**Our Case Number:** ABP-317121-23

**Re:** BusConnects Swords to City Centre Bus Corridor Scheme  
Swords to Dublin City Centre

Re: Case 317121 - BusConnects Swords to City Centre Bus Corridor Scheme

apparatus. The information contained herein does not purport

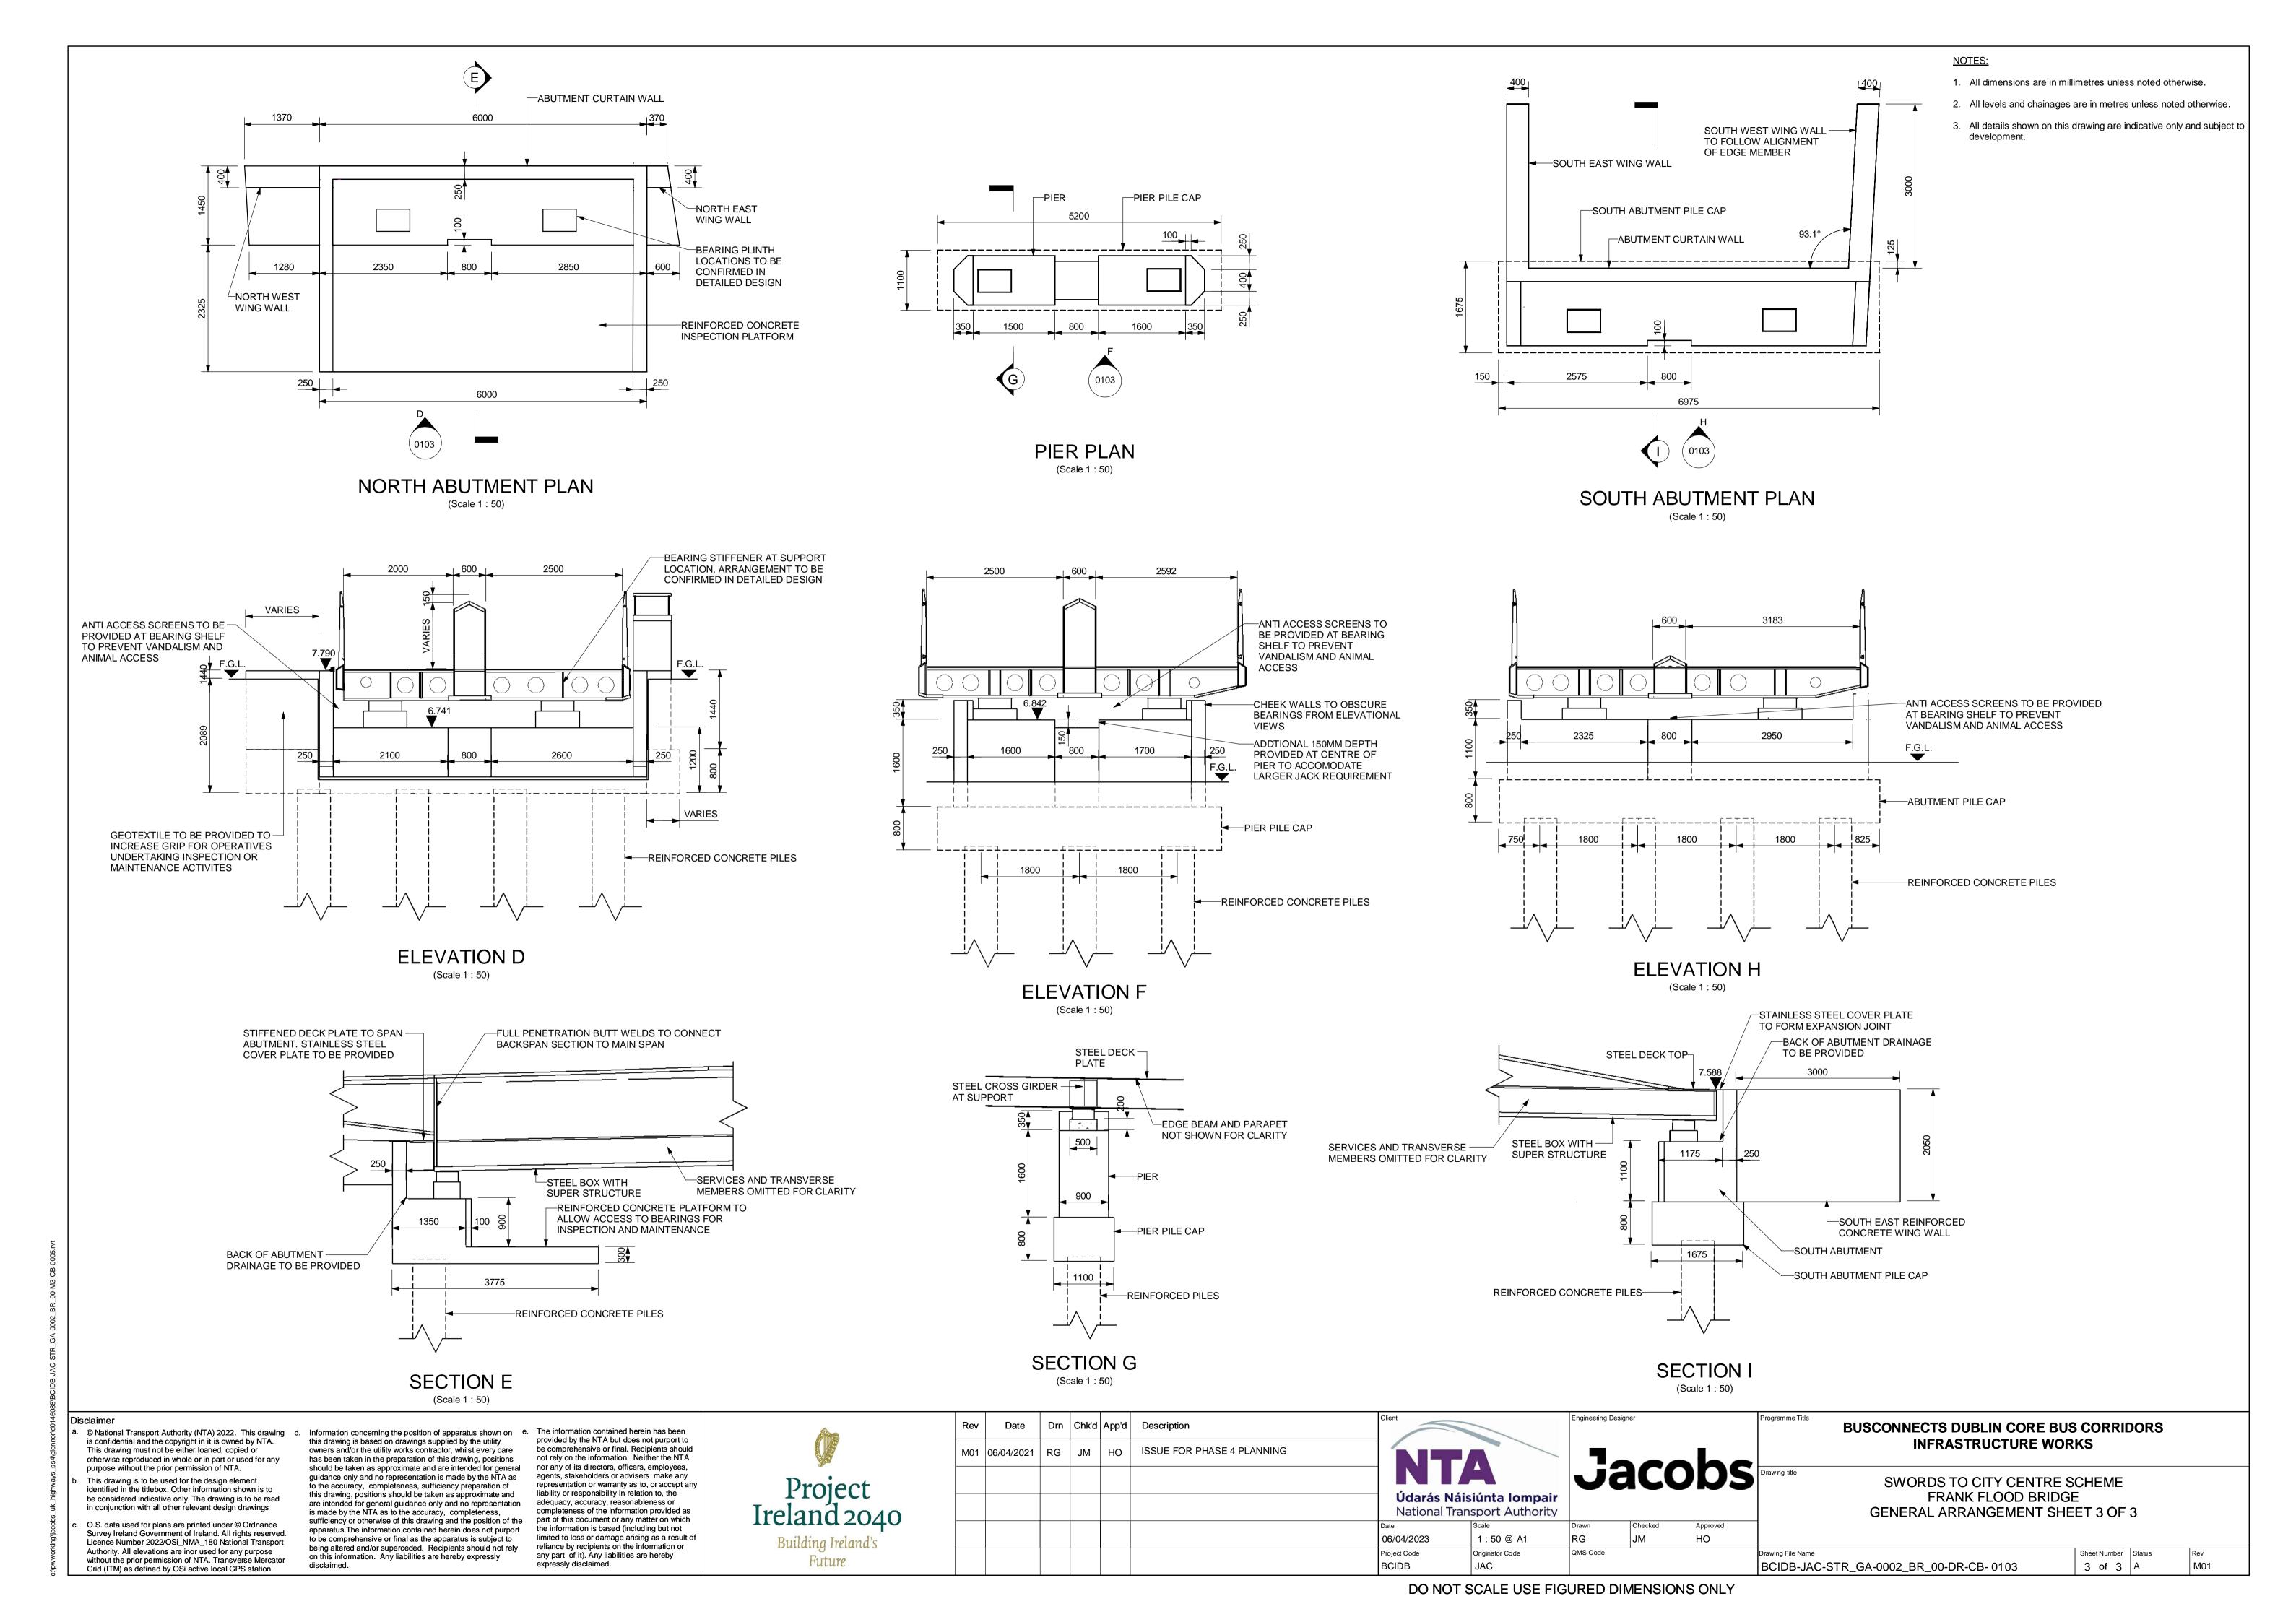
Some constituents have concerns that the modern design of the new pedestrian/cycle bridge at Frank Flood Bridge is not in keeping with the prevalent architectural style of the area (e.g. Edwardian/Victorian) and the existing bridge. While a pastiche treatment is unlikely to be successful something a little less jarring might be more appropriate.
